# *City of Albuquerque*

June 8, 2001

**RE: BAGLEY STUDIO (J14-D140). GRADING AND DRAINAGE PLAN FOR BUILDING PERMIT APPROVAL. ENGINEER'S STAMP DATED MAY 29, 2001.**

BAGLEY STUDIO
GRADING & DRAINAGE PLAN

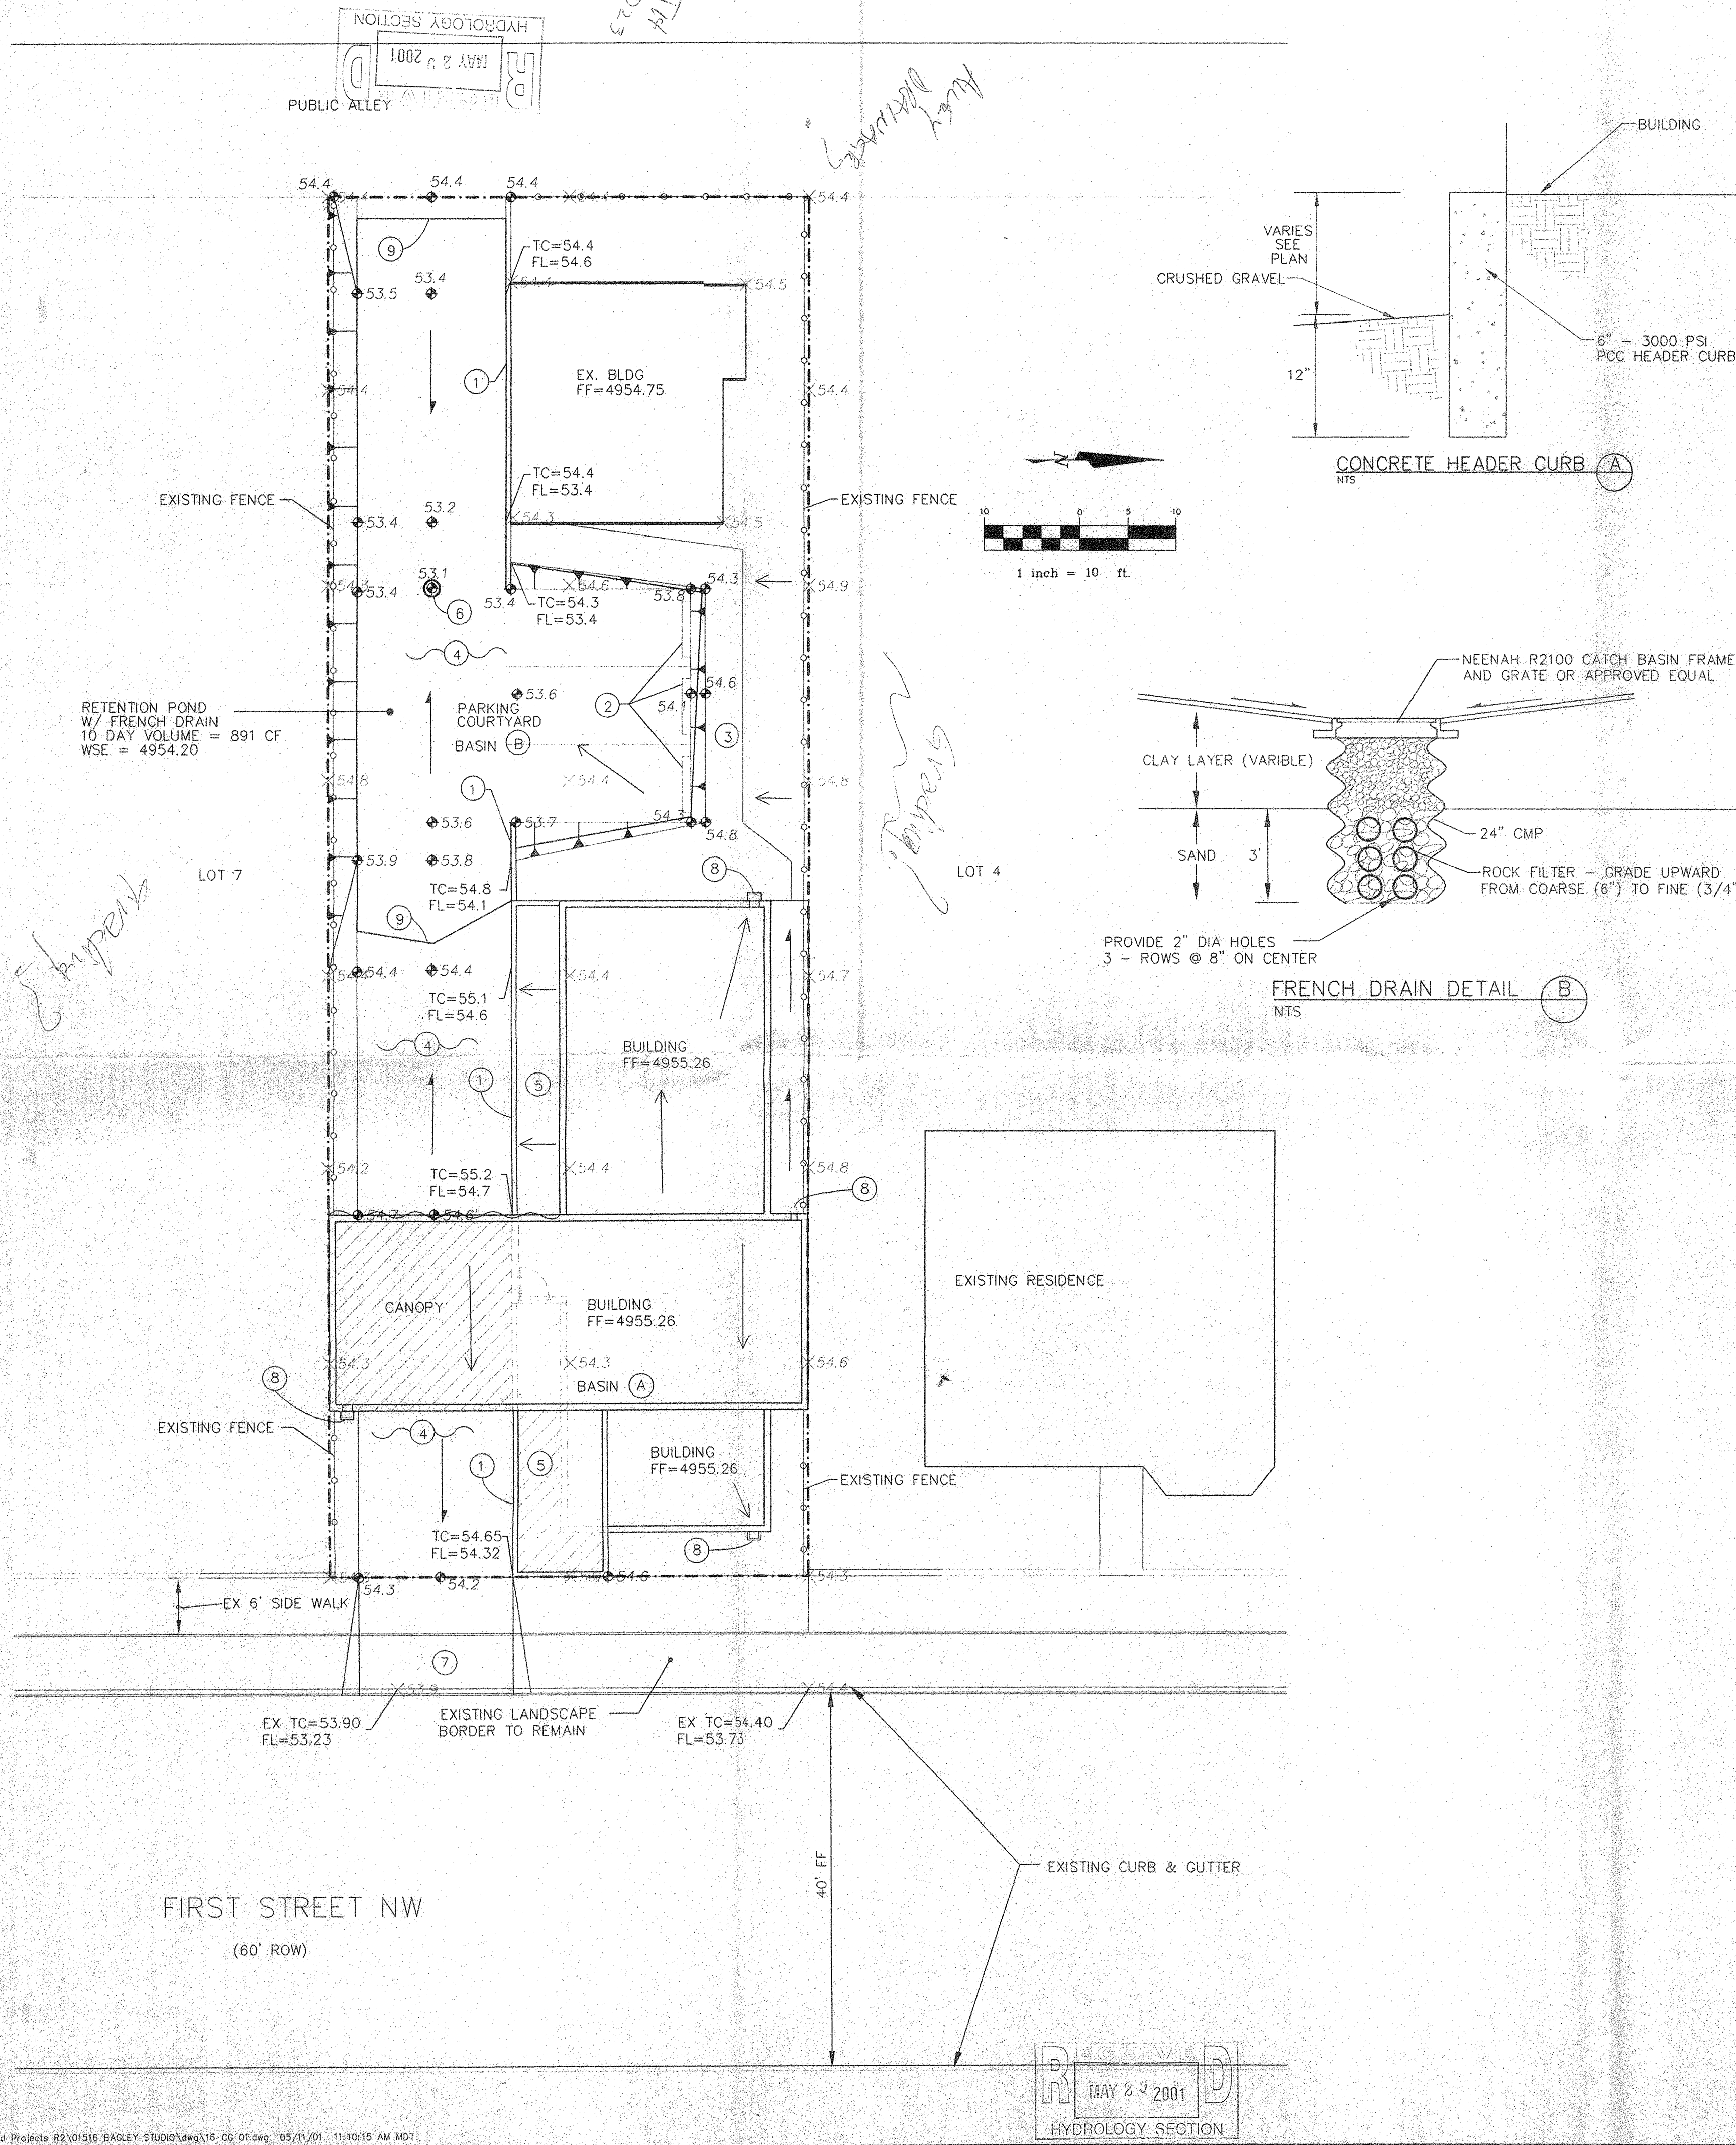
French drains are considered the least desirable answer to such a drainage situation. Under most similar situations, detention ponding with a sump pump has been successfully employed. Check to determine if ponding can be eliminated altogether and the site drained to the street. There are existing storm drains in the area.

Provide the required surrounding topography. It is assumed the public alley has been and will continue to be used for access.
